Preliminary Acceptance Punchlist
El Paso County – Department of Public Works - Stormwater Section

Project Name:	Bent Grass Residential F2
EDARP Filing Number(s):	SF1914, CON2022
ESQCP Number:	ESQ228
Attendees:	DPW SW: Dylan Finley, Ben Jones DPW Development Services: Spencer Pirzadeh, Brad Walters Developer: George Hart, Erin Ganaway
Date of Walk-Thru:	09/13/2023
Walk-Thru Number:	1

C4.06

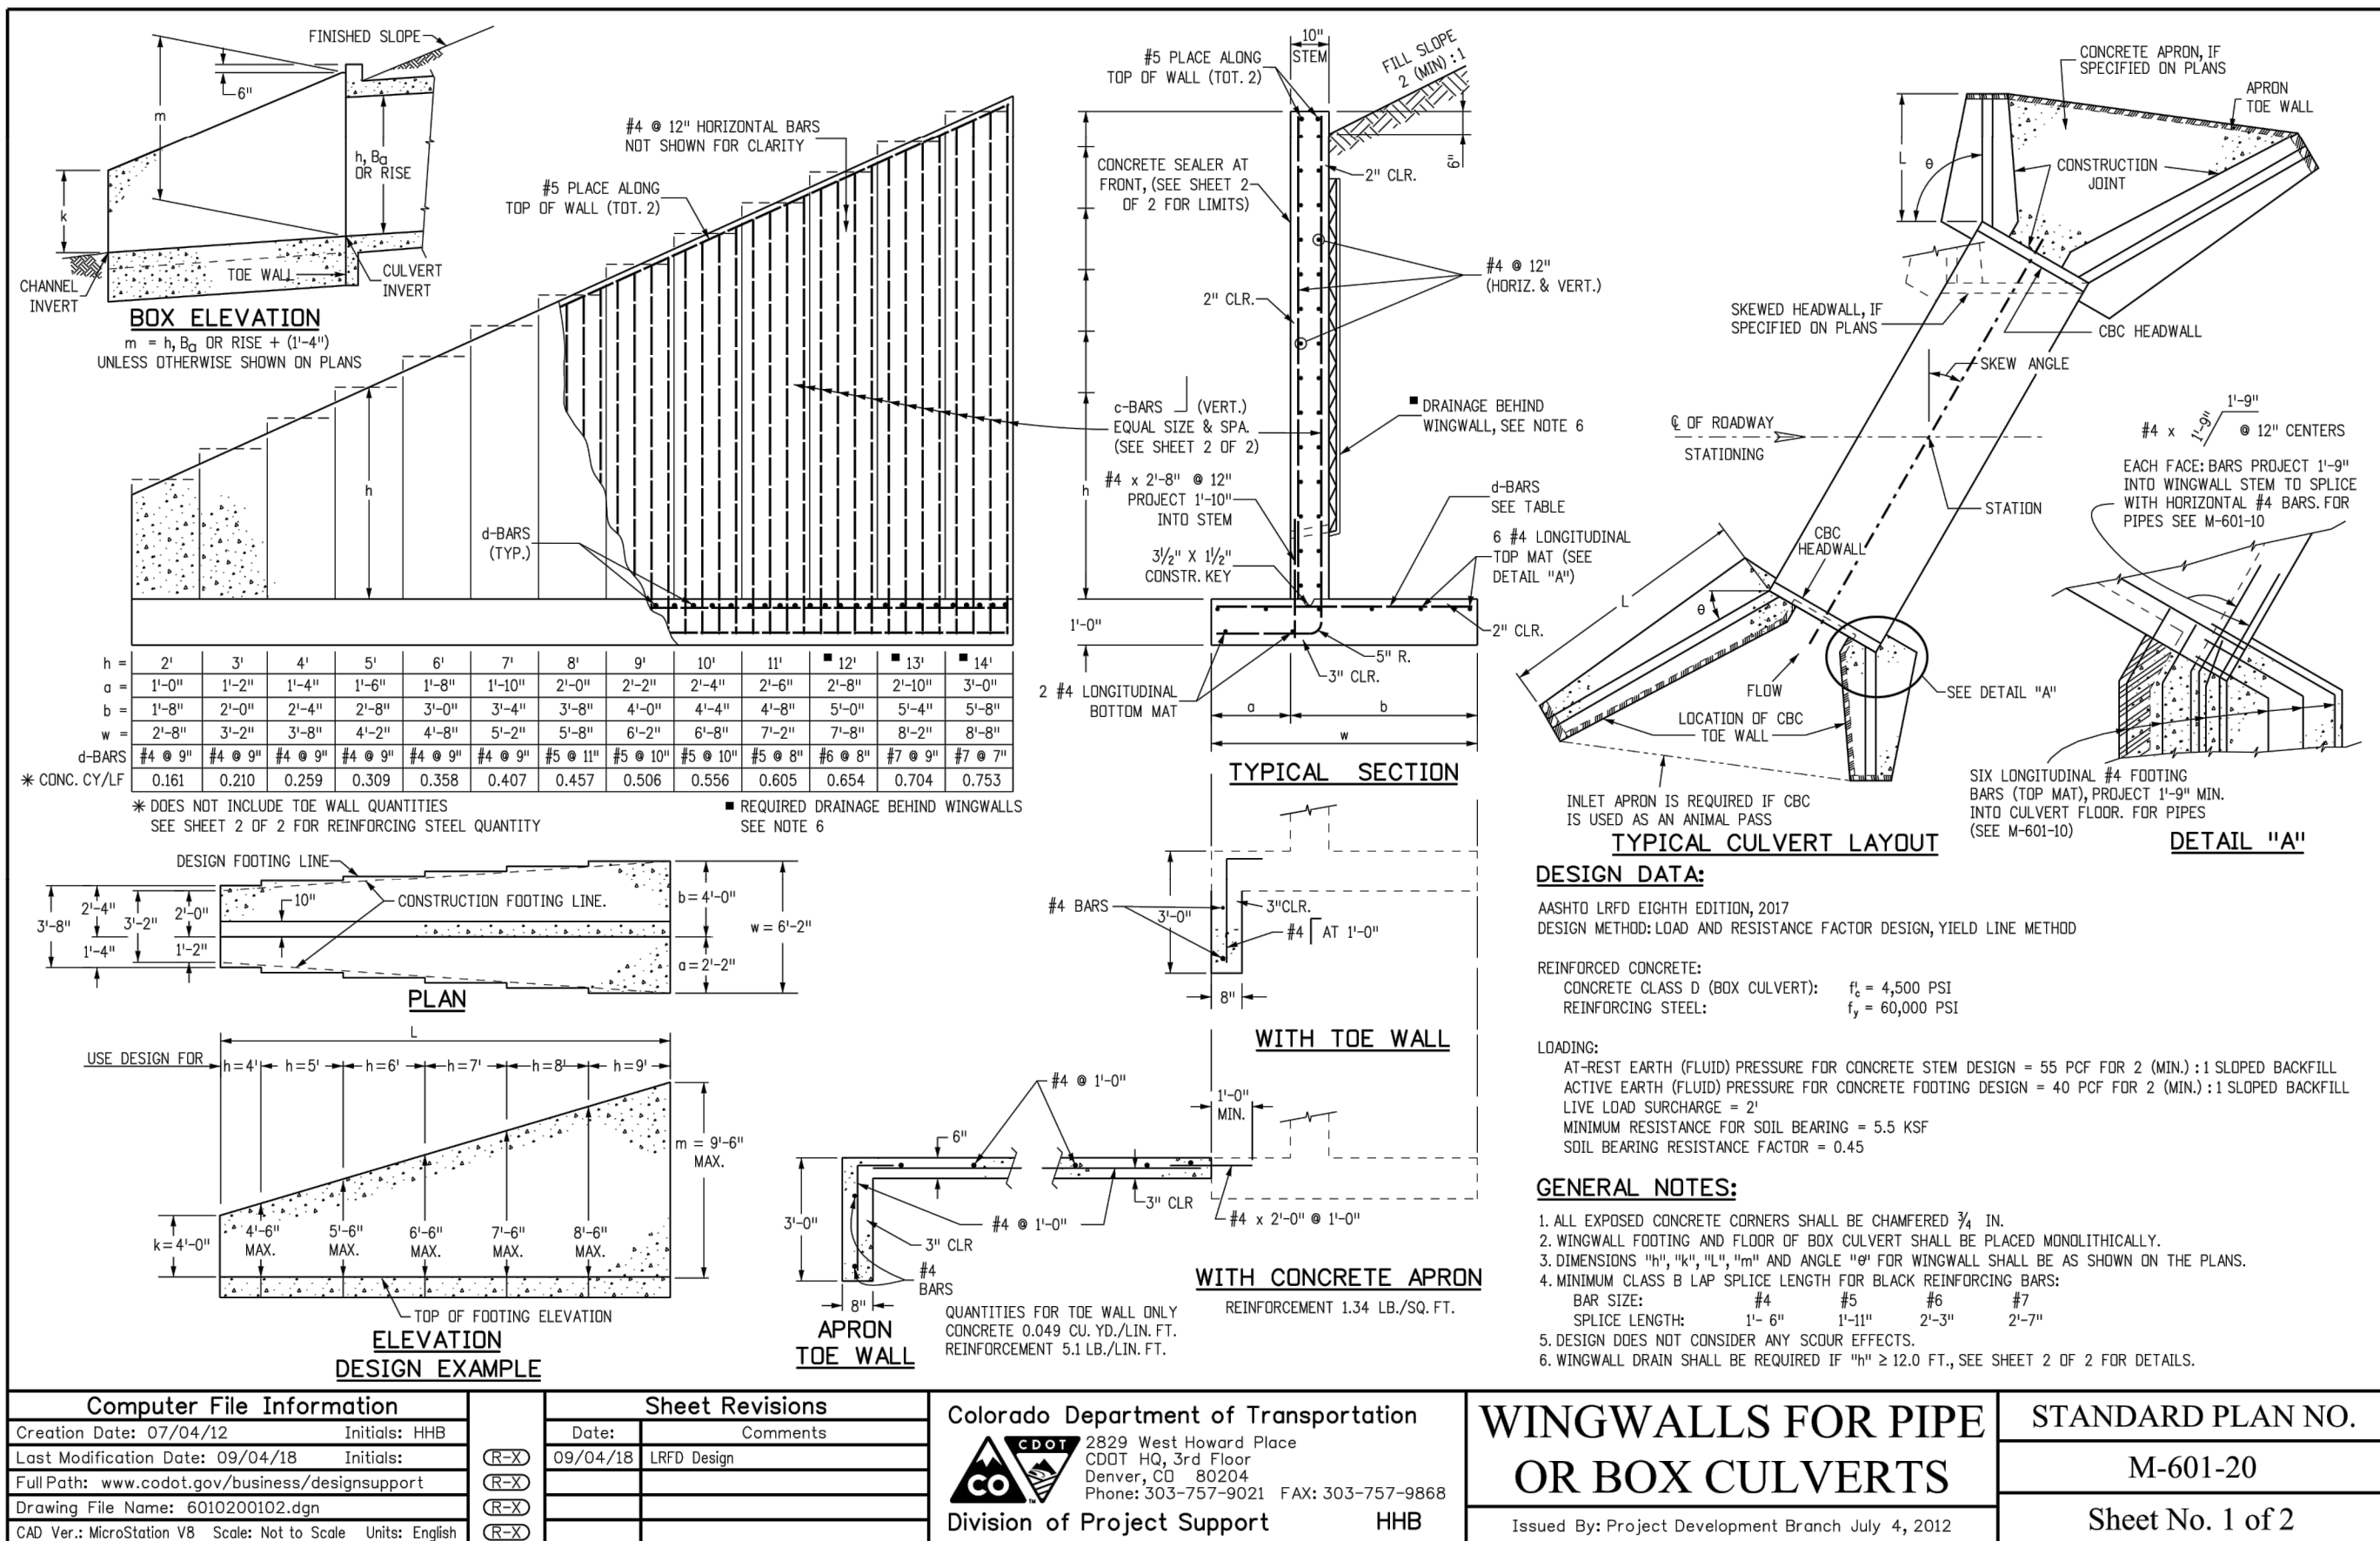
- Install drop structure in main channel with 24” grouted boulders. (West of Swale B).
- Also missing:
 - 1.5’ high riprap check dam
 - Type M Soil Riprap 24” deep
 - Six-foot deep cutoff wall
 - Three-foot deep cutoff wall
 - Type L riprap 18” deep.

G2.03
Sheet 8 of 29

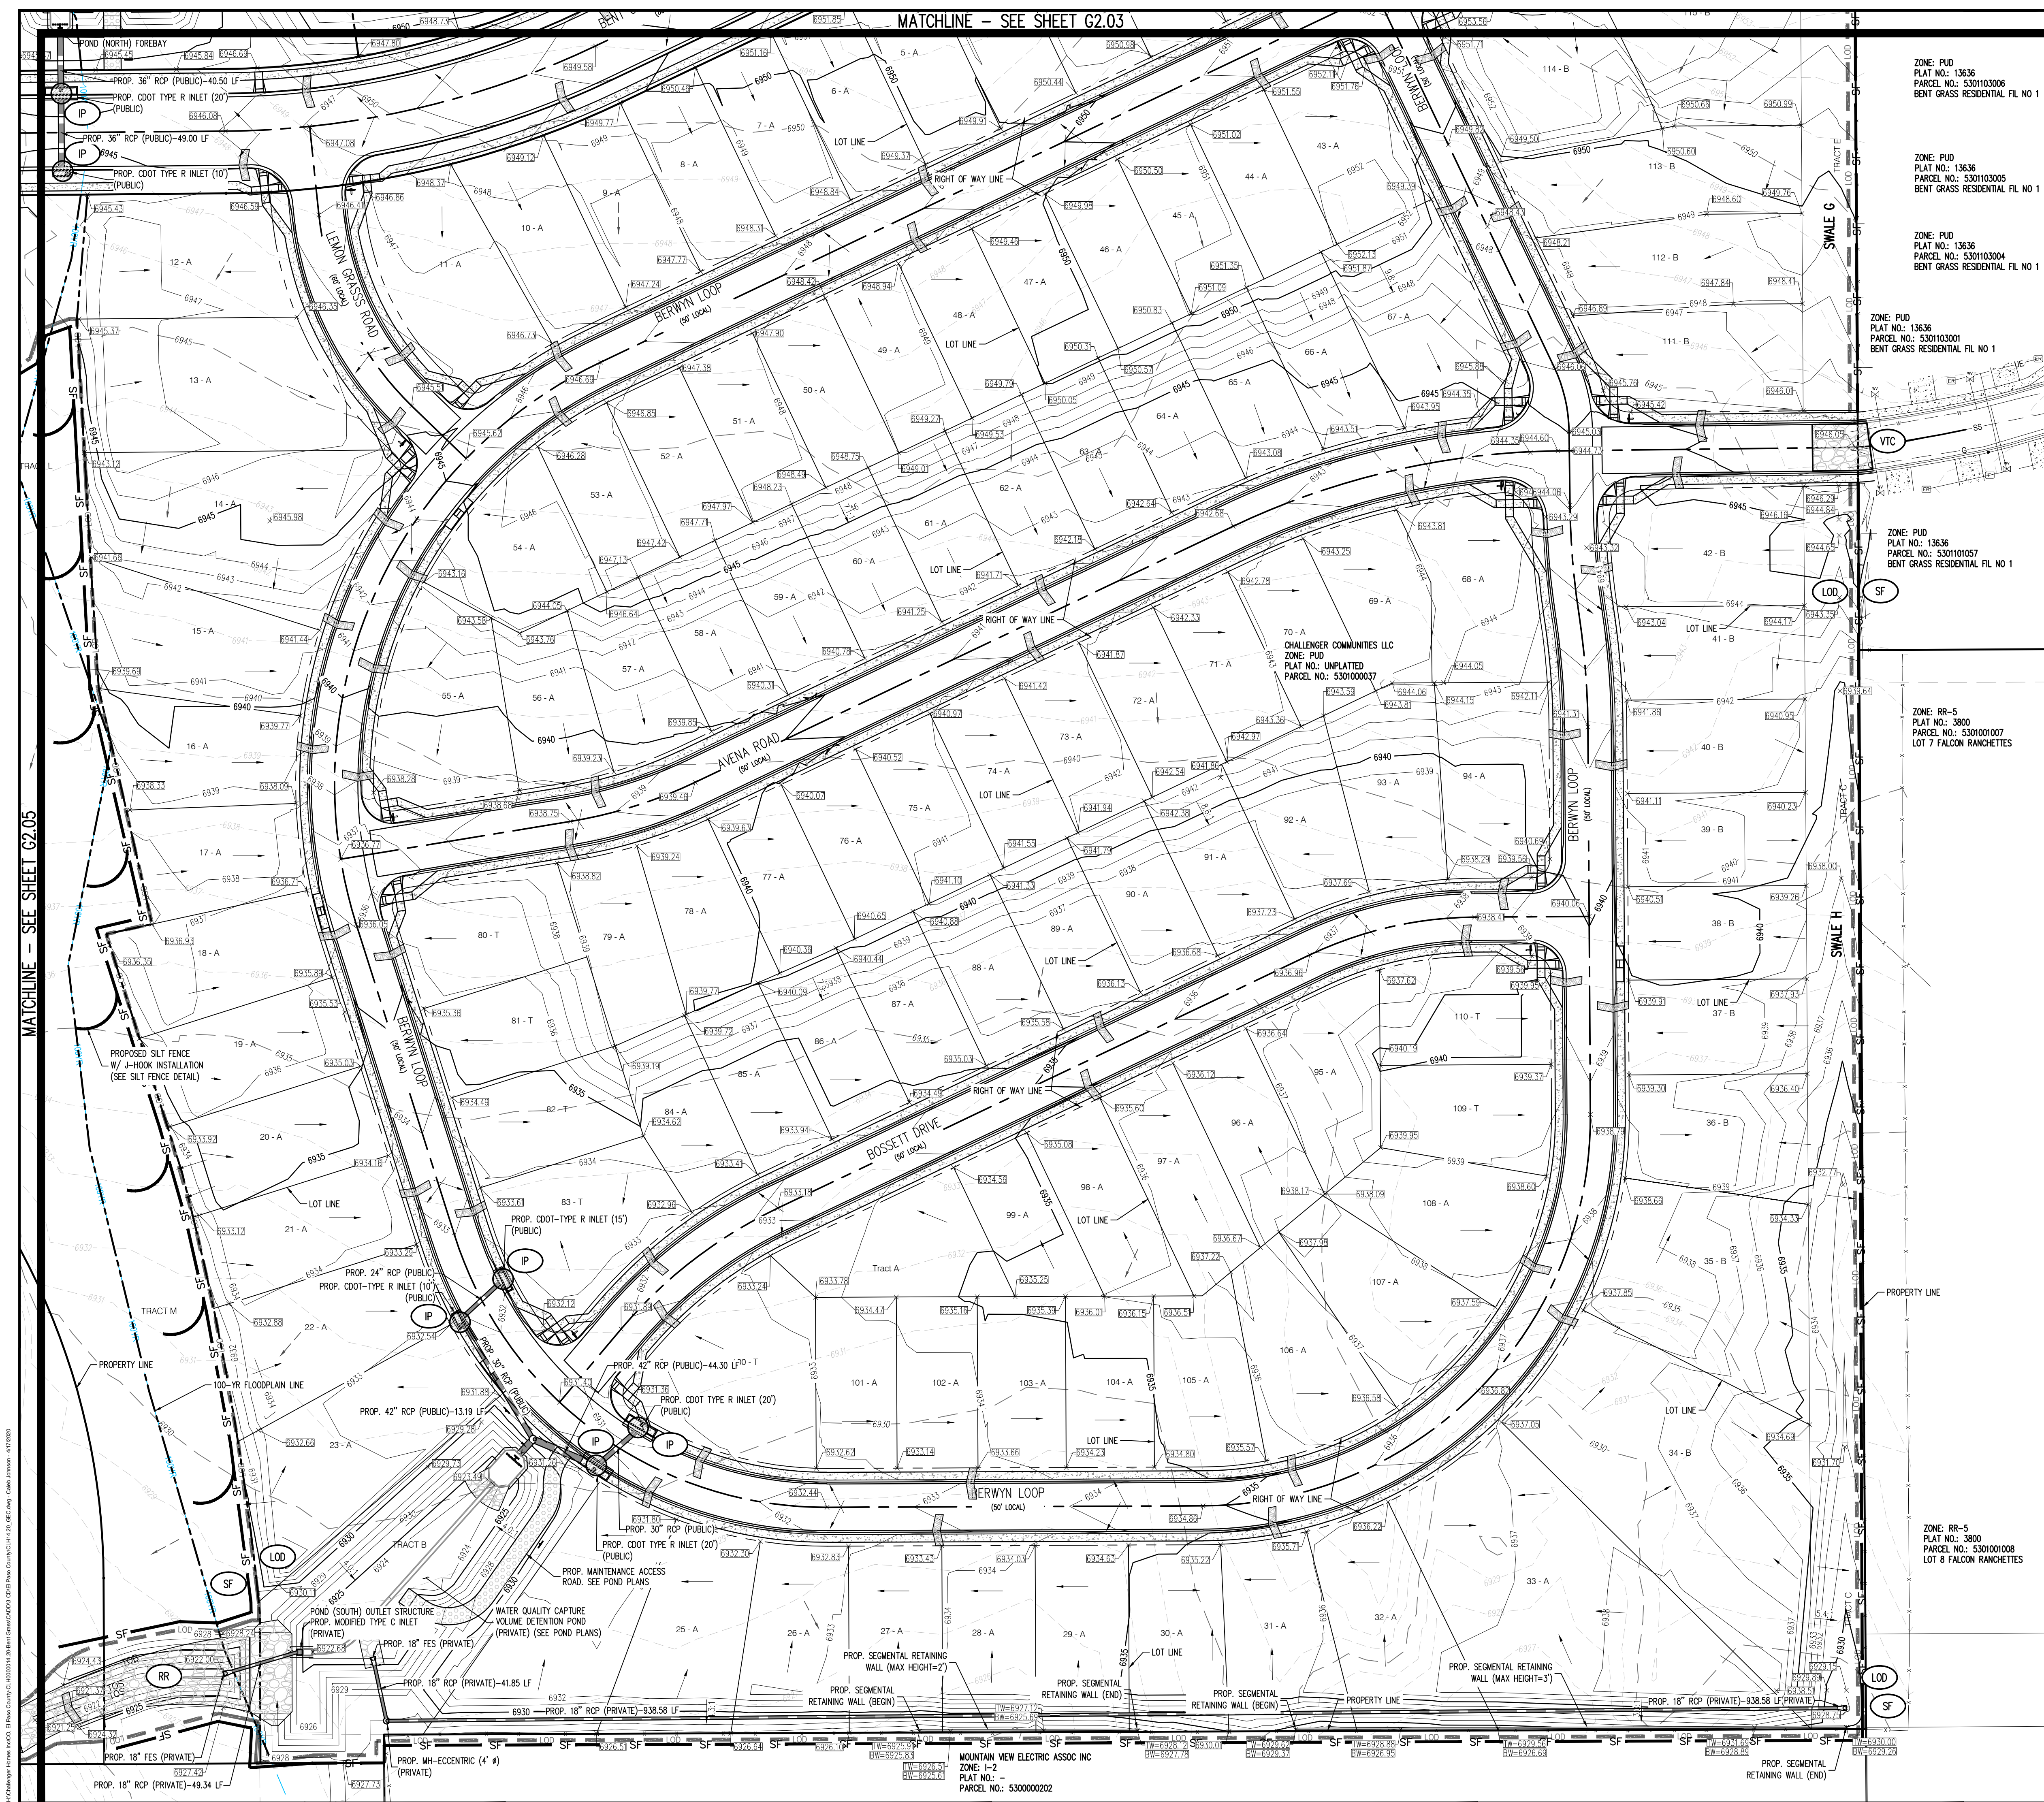
- Swale A has standing water at point near channel. Cat tails present. Sediment eroding into channel.
- Swale B (which is tributary to North Pond) not installed per plan. See GEC Plan Sheet G2.03 and G5.01.
- Swale E missing north pipe and riprap pad.
- Swale F missing riprap.
- Swale G not installed per plan.
- Swale H not installed per plan.

G2.04
Sheet 9 of 29

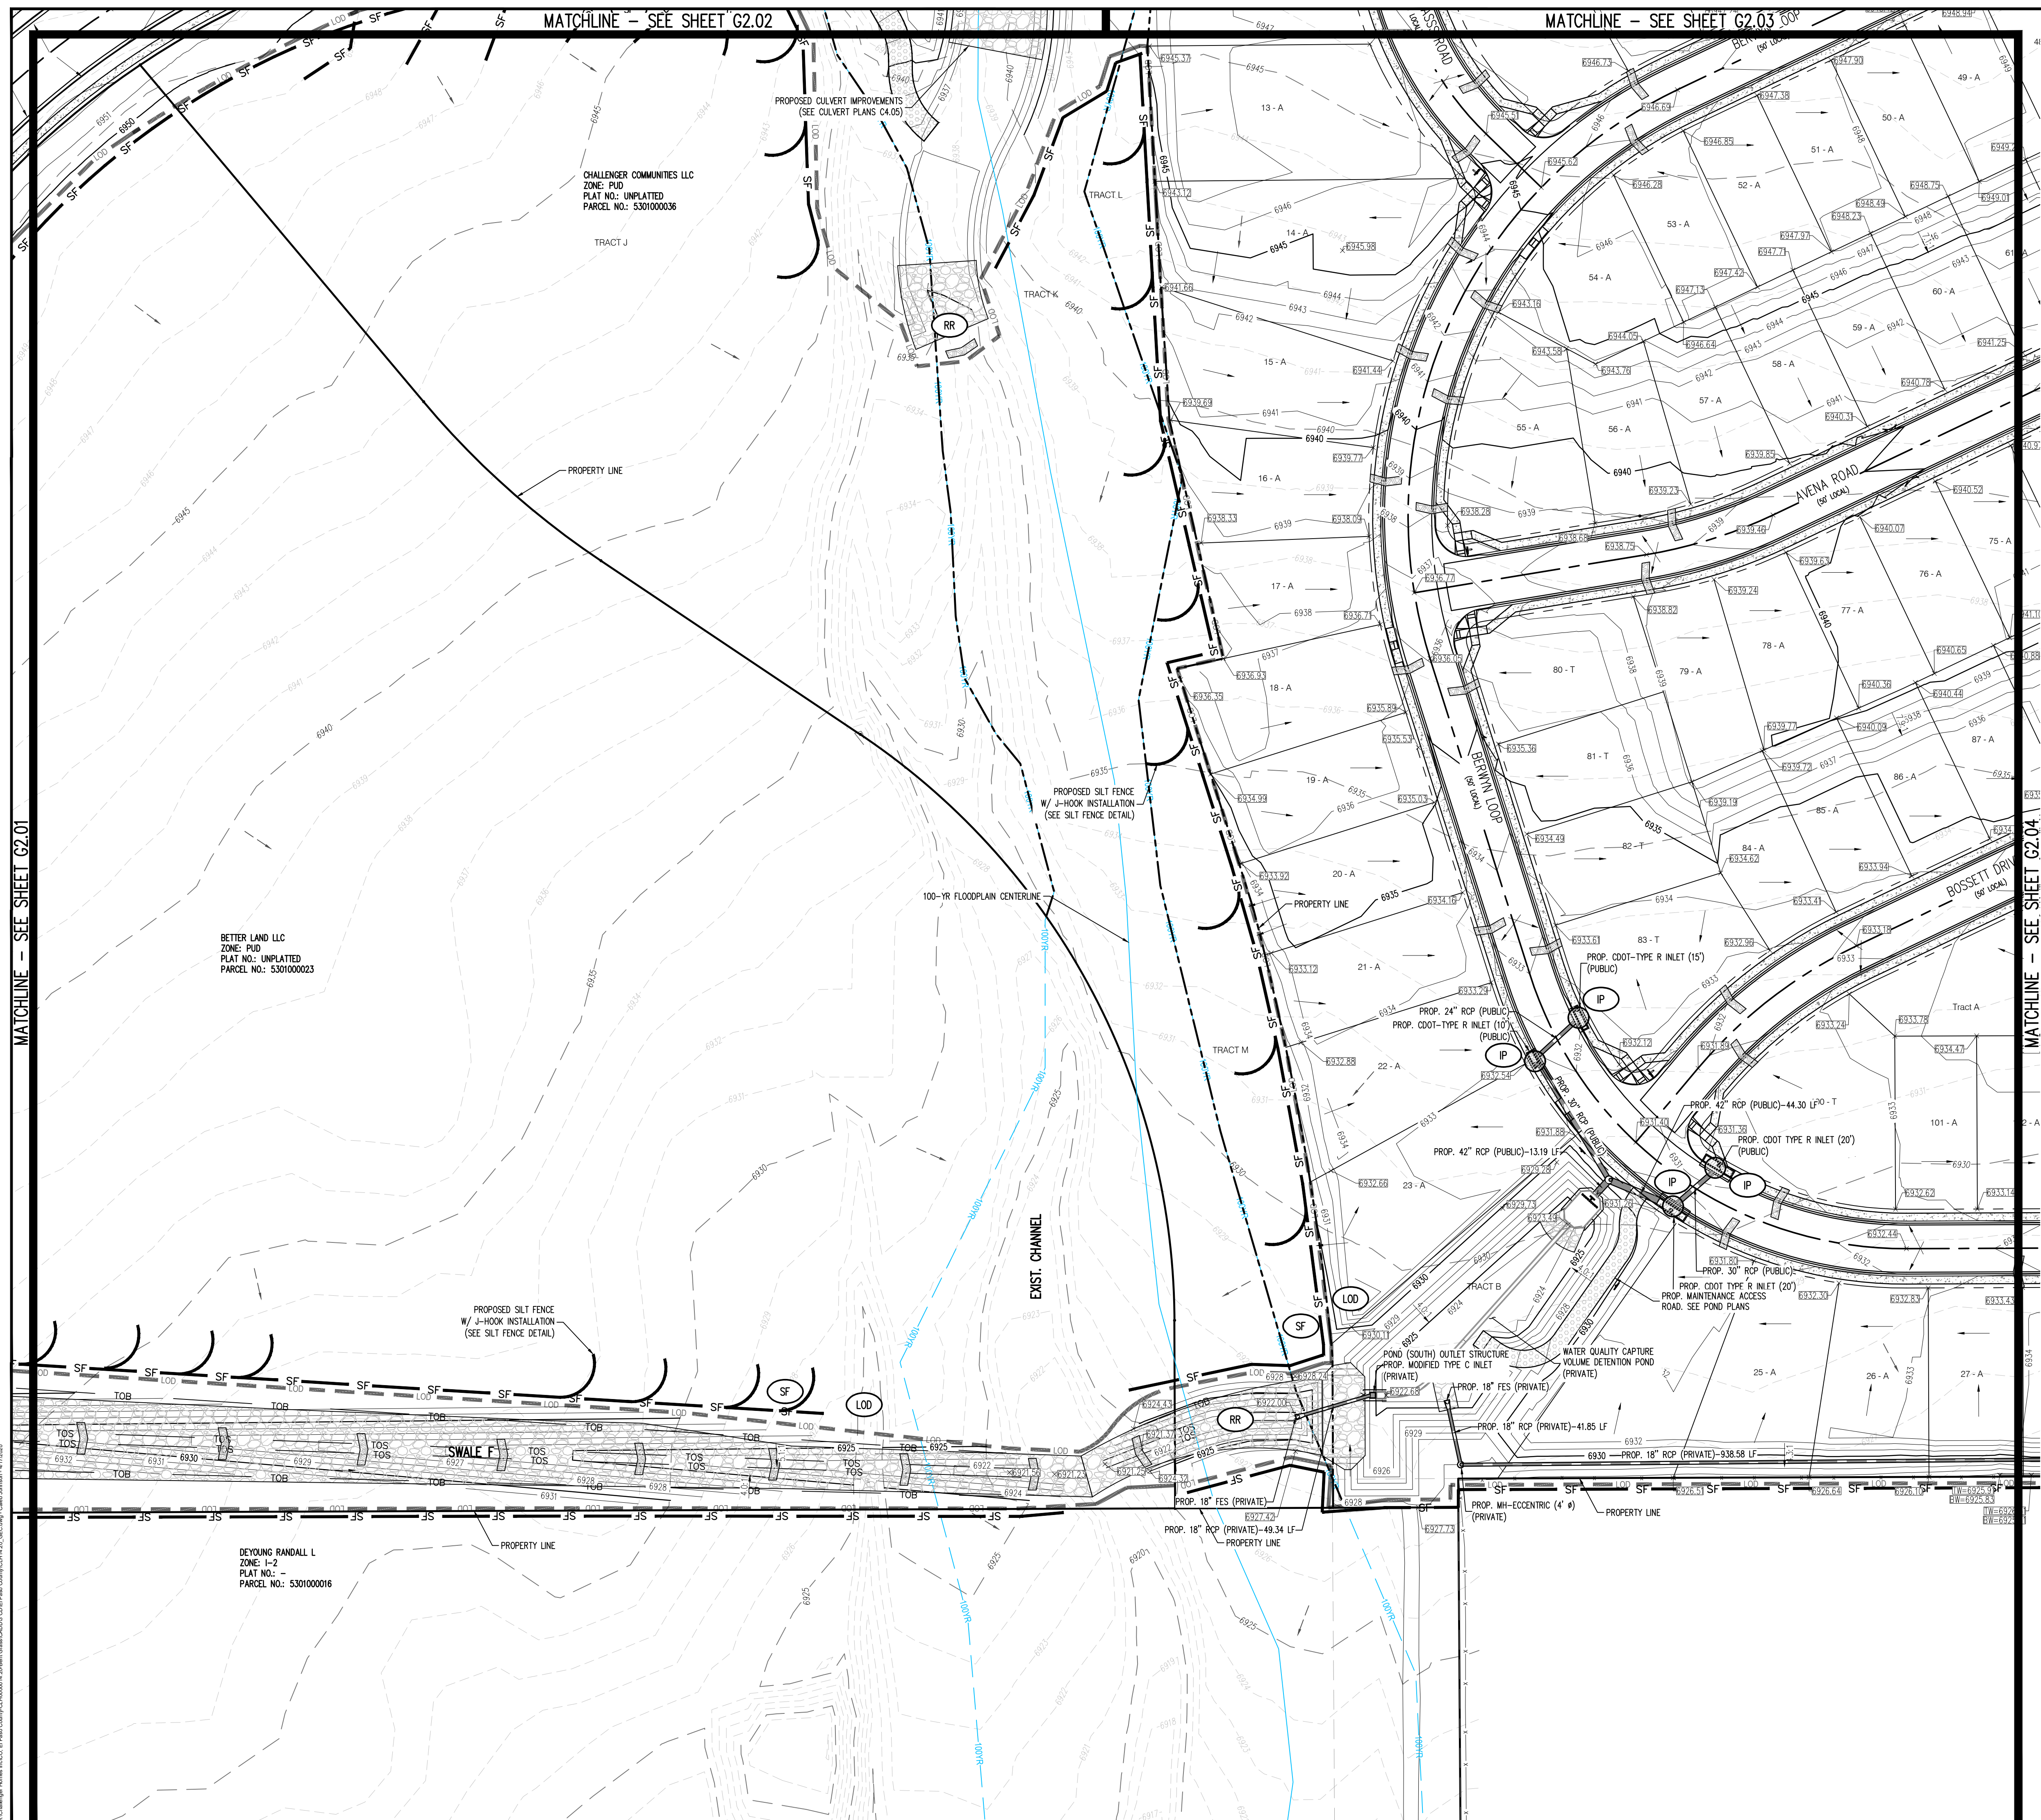
Stormwater Inlet Structures [GEC pages 2.04]:

- Inlets that need to be cleaned of debris: Rock socks present inside of the inlet box.
 - Inlets near south pond marked with green paint.
 - South inlet above box culvert
